Planning Application Response

Organisation:	Barnsley Council
Detail:	Re-engineering and restoration of Yew Tree Quarry through the importation of non-hazardous excavated soil materials – Stairfoot Brickworks, Wombwell Lane
Planning Ref:	2025/0908
Link:	Application Details
Closing Date:	30 th March 2026

Response to:	developmentmanagement@barnsley.gov.uk / helenwillows@barnsley.gov.uk
Submitted by	Trans Pennine Trail National Office & Walk Wheel Cycle Trust
Date:	30 th March 2026
<p>The Trans Pennine Trail National Office (TPT) and the Walk Wheel Cycle Trust (formerly Sustrans) (NCN) welcome the opportunity to respond further to this planning application, in relation to the documents you state:</p> <p>A – Amended Proposed Site Access Arrangements – 12th March B – Application Boundary – 10th February C – Delivery Management Plan – 12th March</p> <p>The map below shows the development location and alignment of TPT/NCN:</p> <p>Yellow: TPT/NCN Red: Current Application Blue: 2022/ENQ/00353 - Restoration and aftercare scheme, Stairfoot Quarry (which also includes the current application area)</p>

Proposed Site Access Arrangements

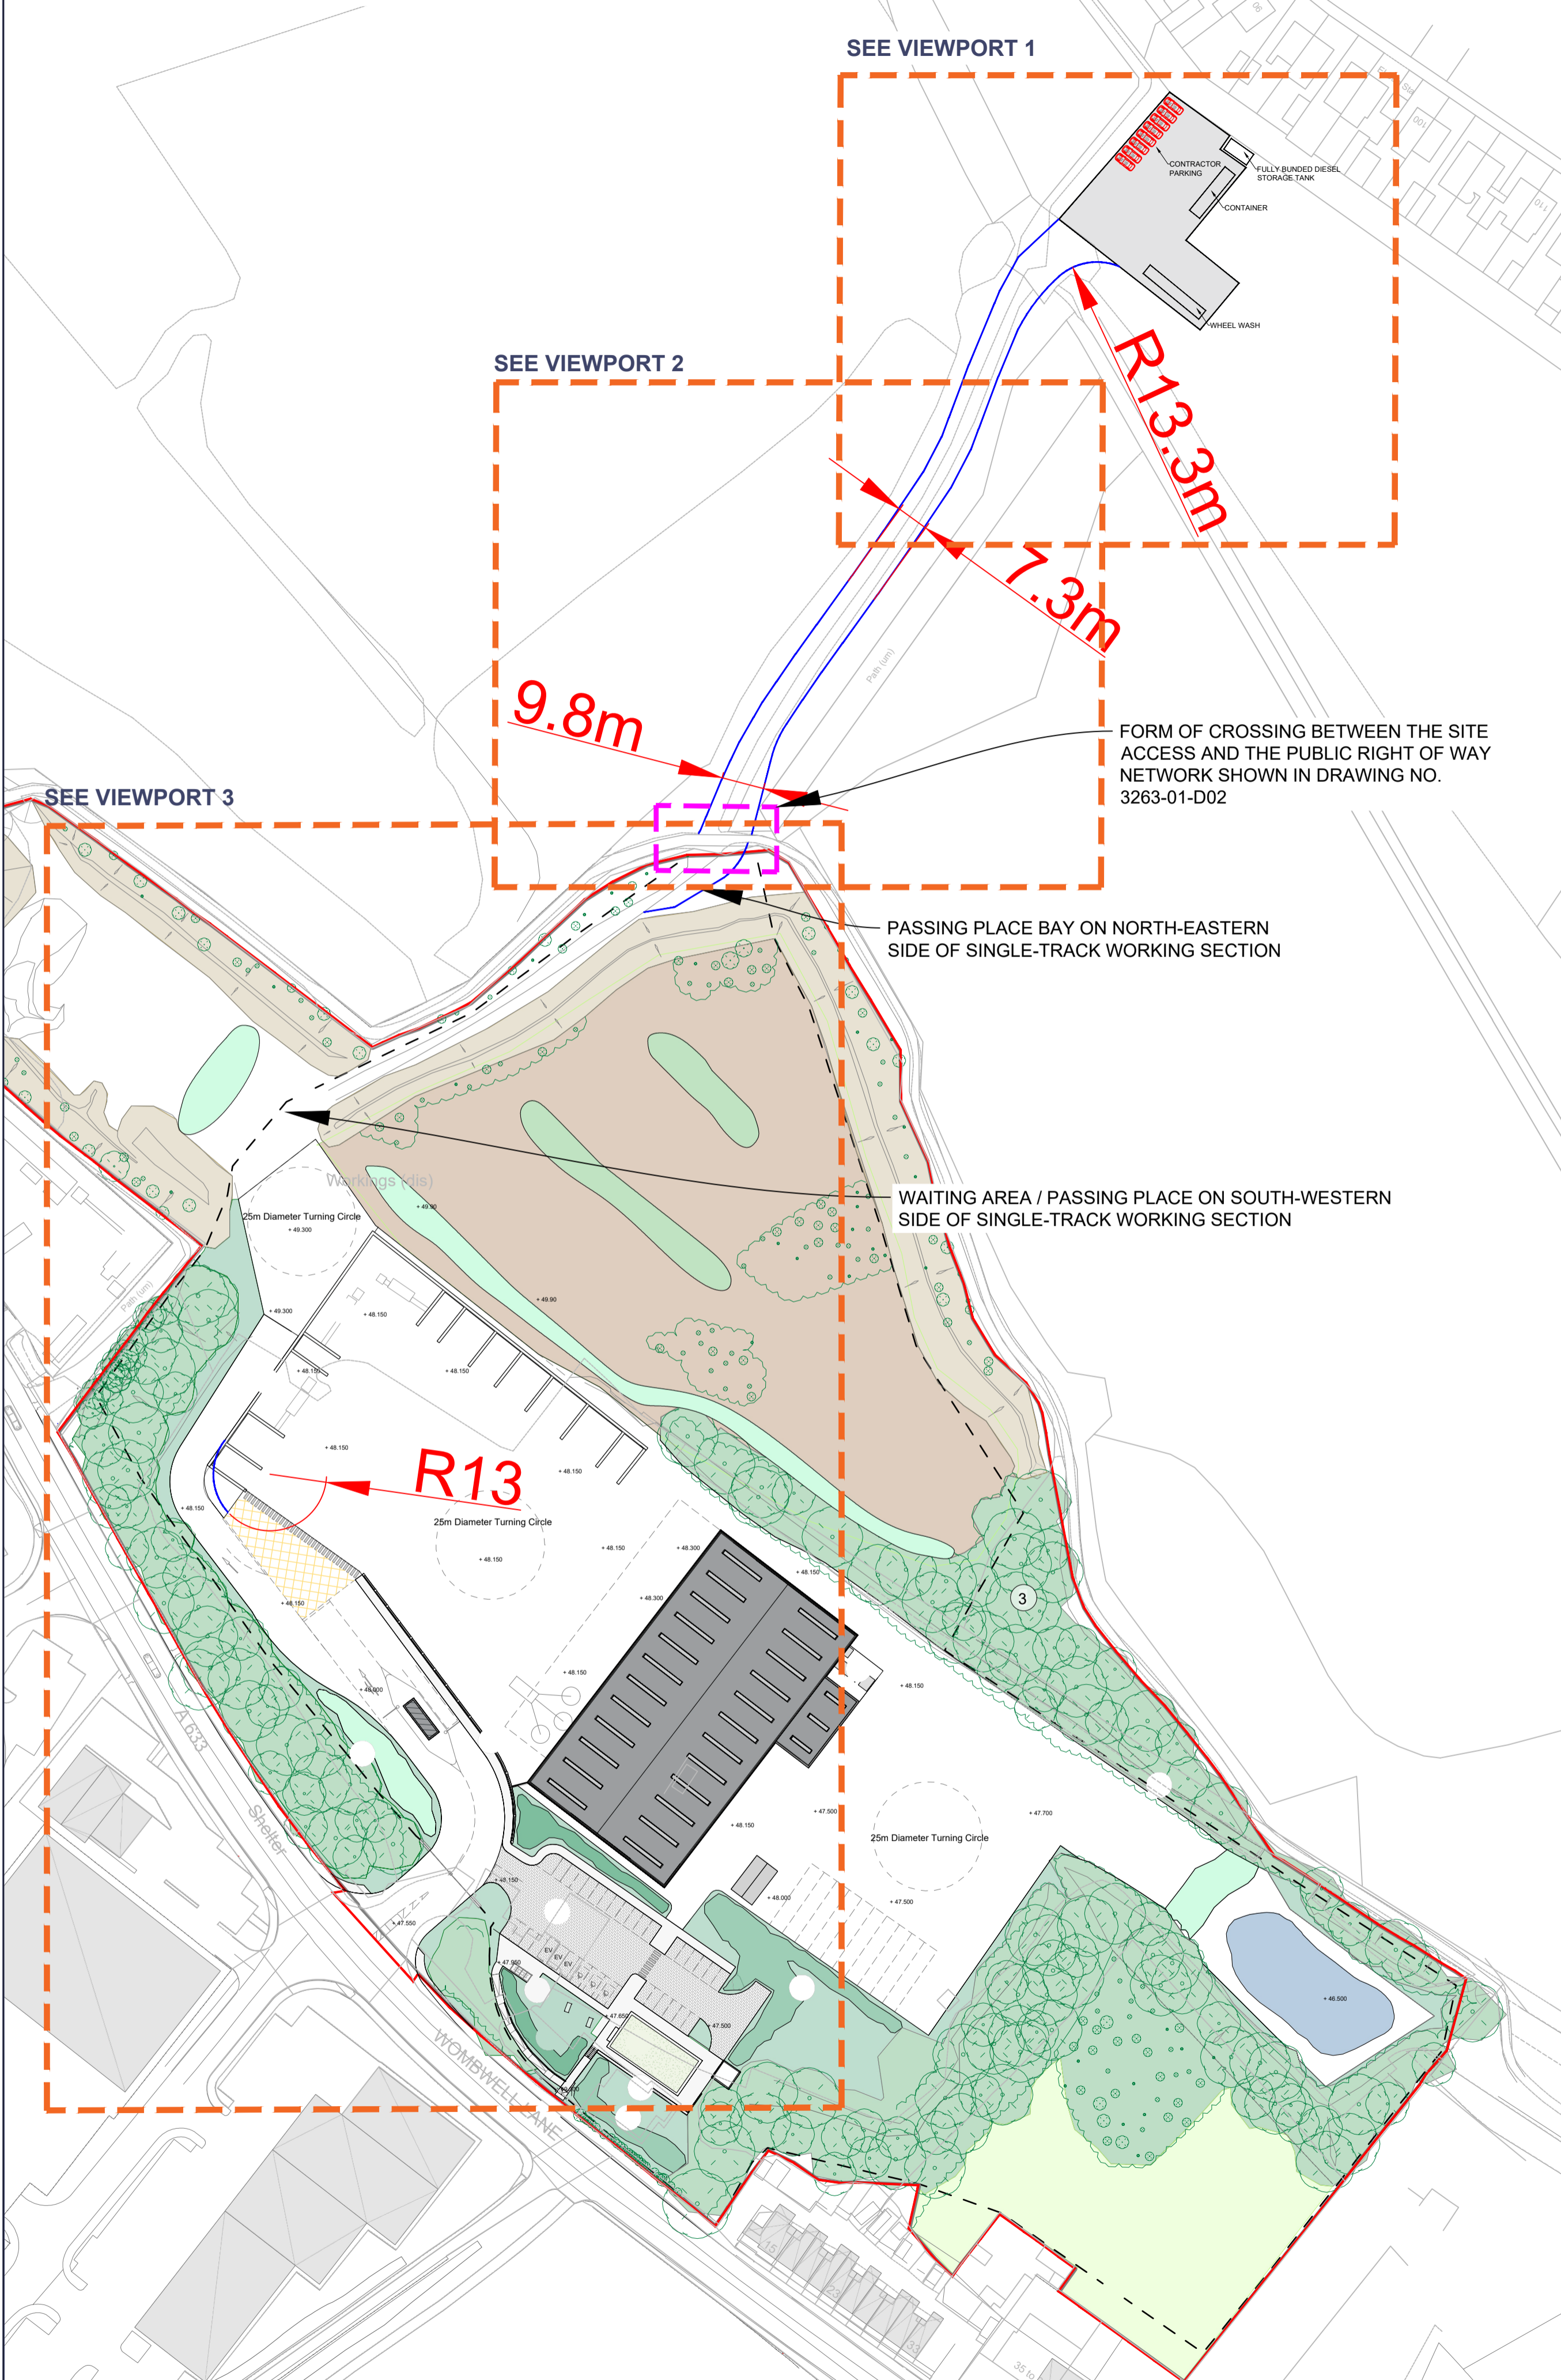
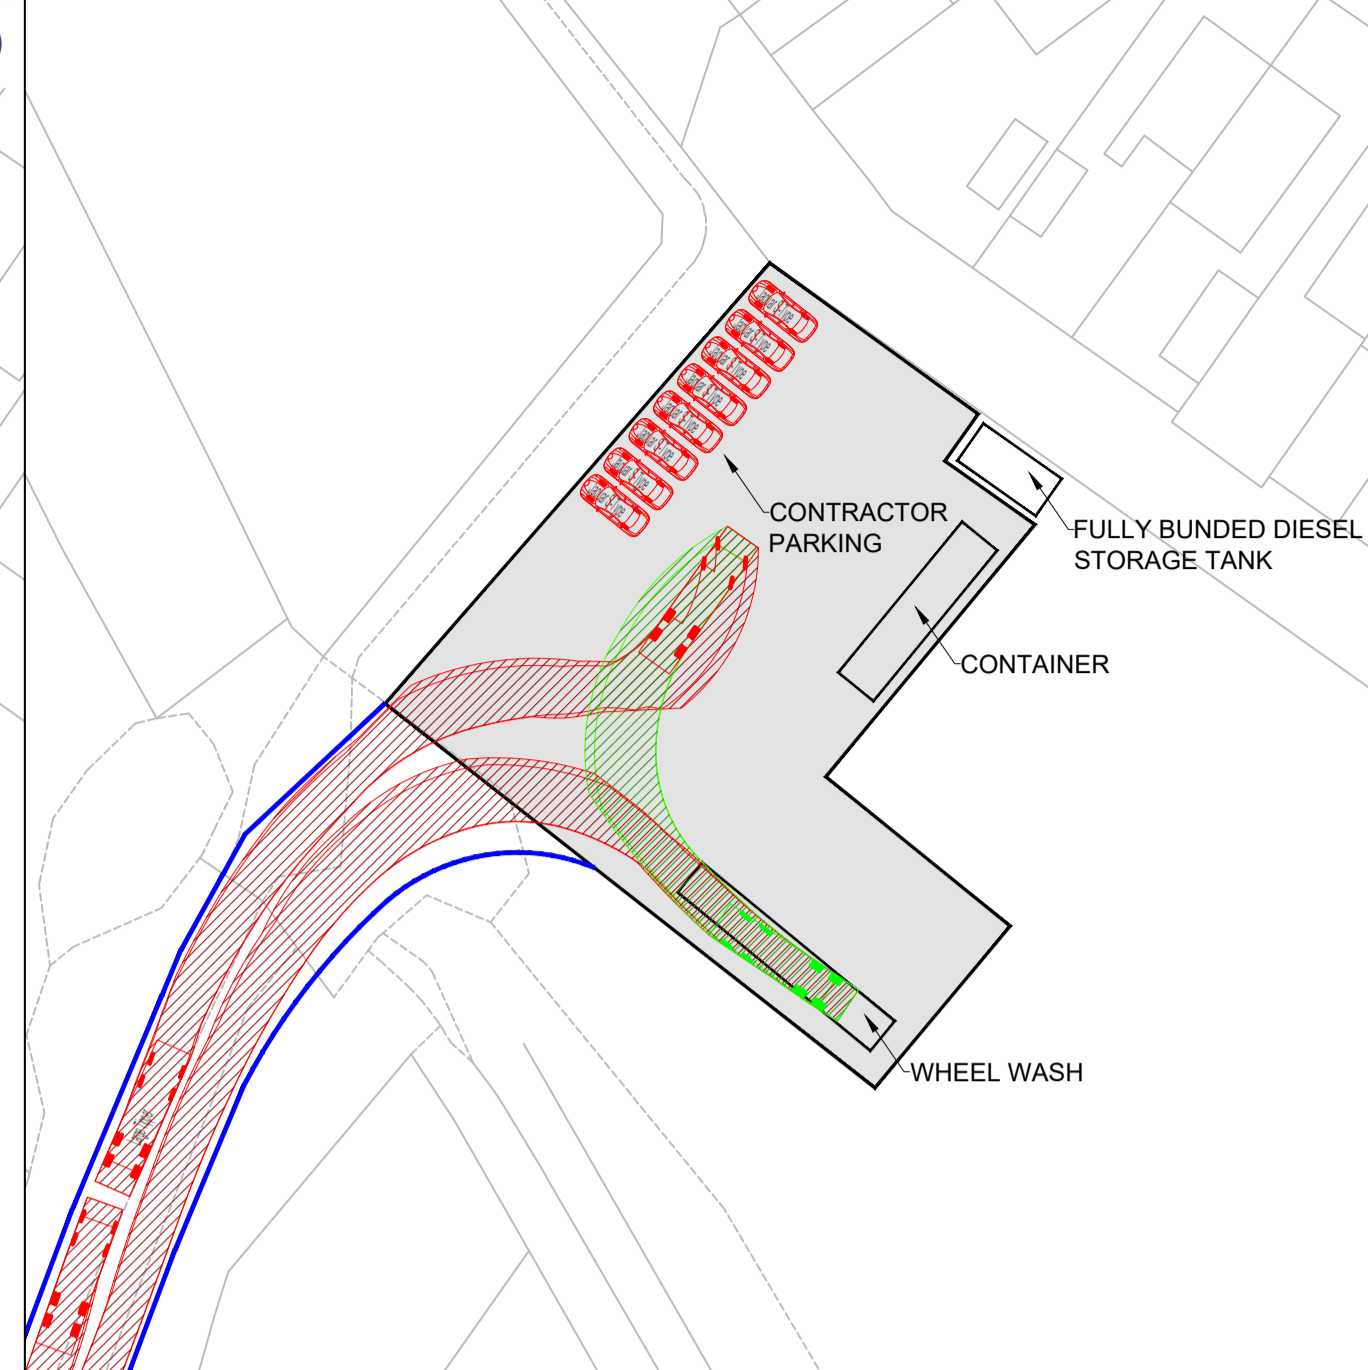
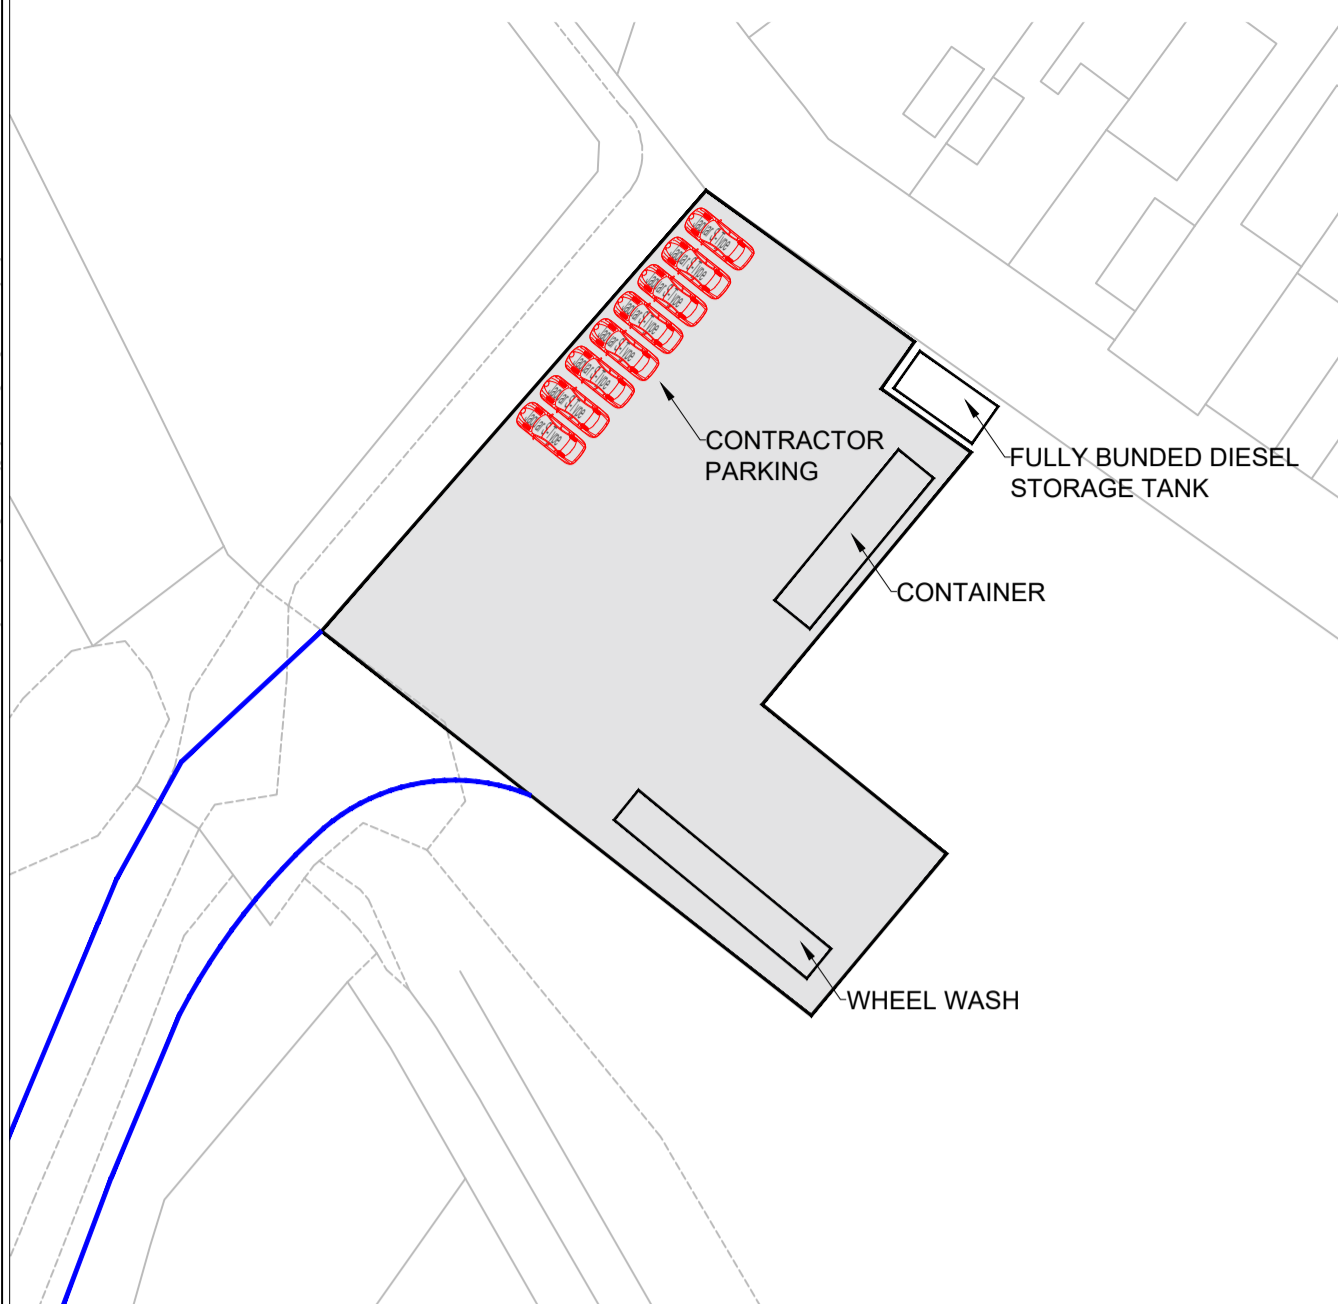
Is this the location of the security office/vehicle check-in? If so, please label on plan:

3.4.1	Notes security gate that drivers should report into – this isn’t clearly shown on the Site Access Arrangement Plan provided.
3.4.2	The commitment for a banksman to be present at the RPWO crossing at all times during operating hours is noted and appreciated.
